**From:** Rodenbeck, Jay B.  
**Sent:** Friday, August 21, 2020 4:26 PM  
**To:** Wolfley, Jolene <[jwolfley@cabq.gov](mailto:jwolfley@cabq.gov)>; Gould, Maggie S. <[MGould@cabq.gov](mailto:MGould@cabq.gov)>  
**Subject:** FW: PR-2020-004030

**From:** Rodenbeck, Jay B.  
**Sent:** Friday, August 21, 2020 4:26 PM  
**To:** 'Richard Stevenson' <[rstevenson@tierrawestllc.com](mailto:rstevenson@tierrawestllc.com)>  
**Subject:** PR-2020-004030

Staff was wondering for the apartments at Golf Course and Black Arroyo (PR-2020-004030) if you have received Water Board approval yet? Also, staff has some ideas regarding the natural shrubbery against the residential wall of the 7Bar neighborhood to the east, and some pictures are attached of the shrubbery.

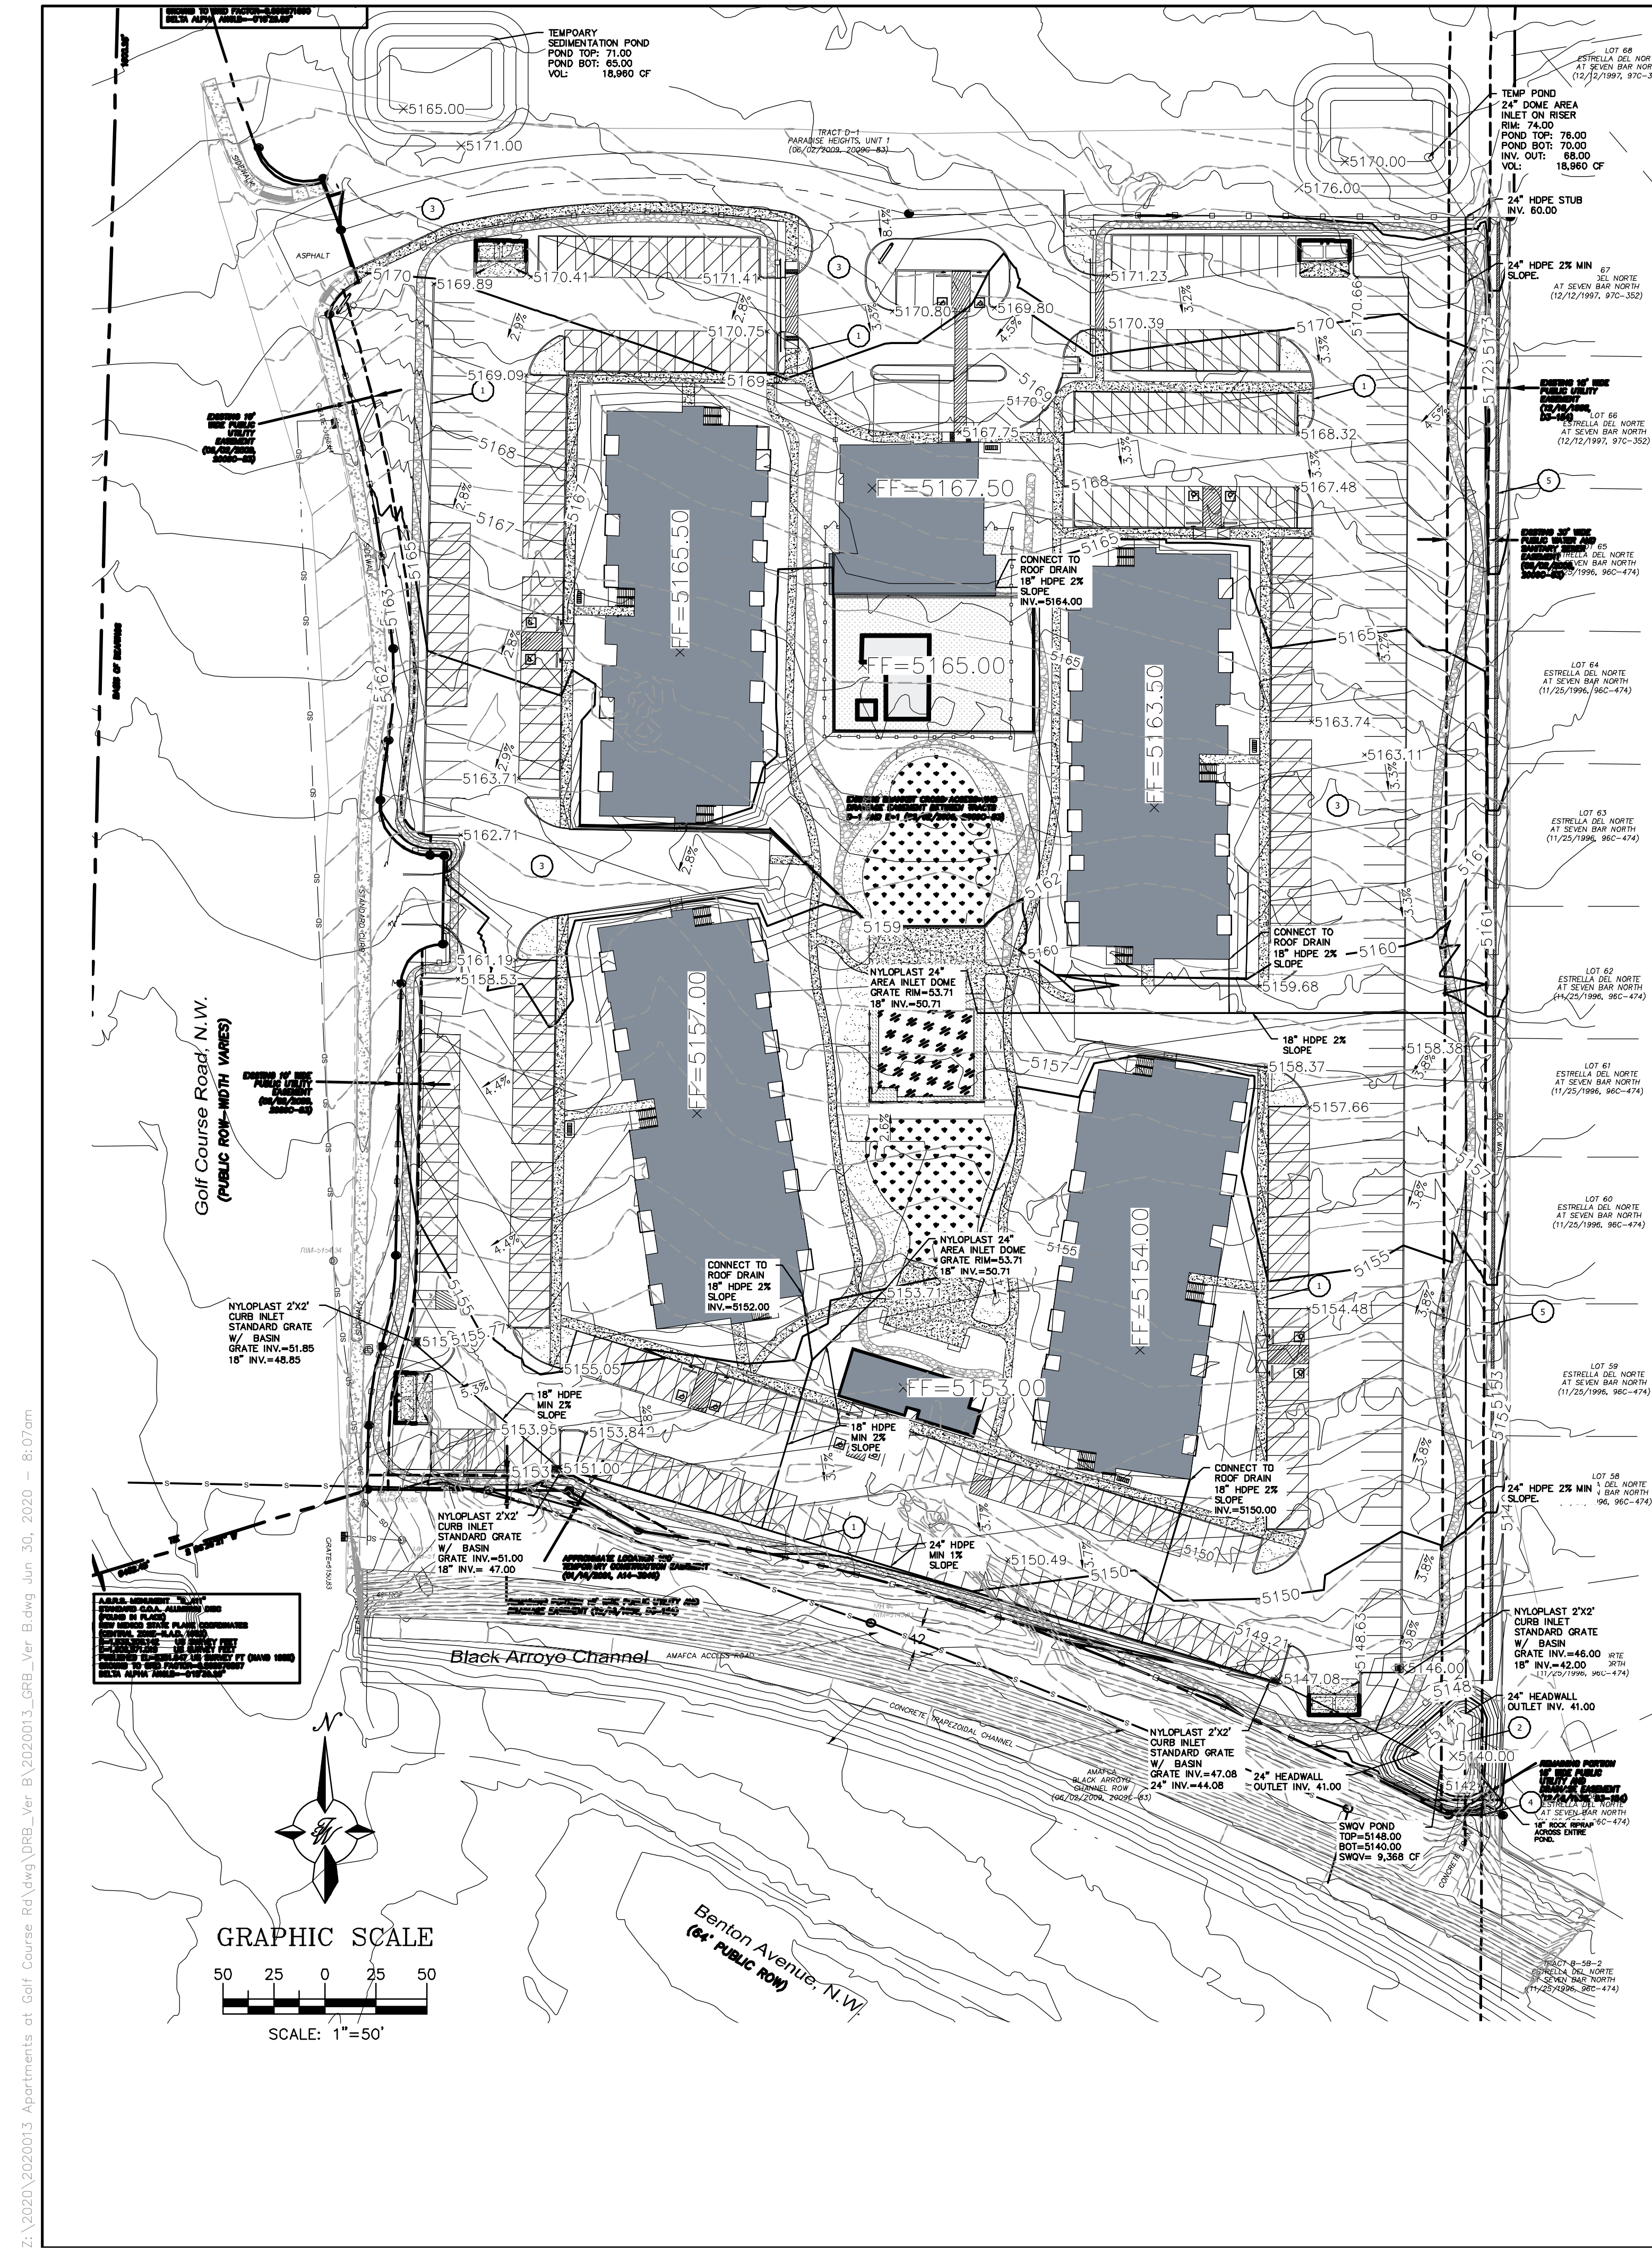
Planning staff feels that a break in the shrubs is about 5-8 feet from the residential wall and is somewhat continuous. Staff feels that this would be a perfect place to put the wall, allowing it to meander.
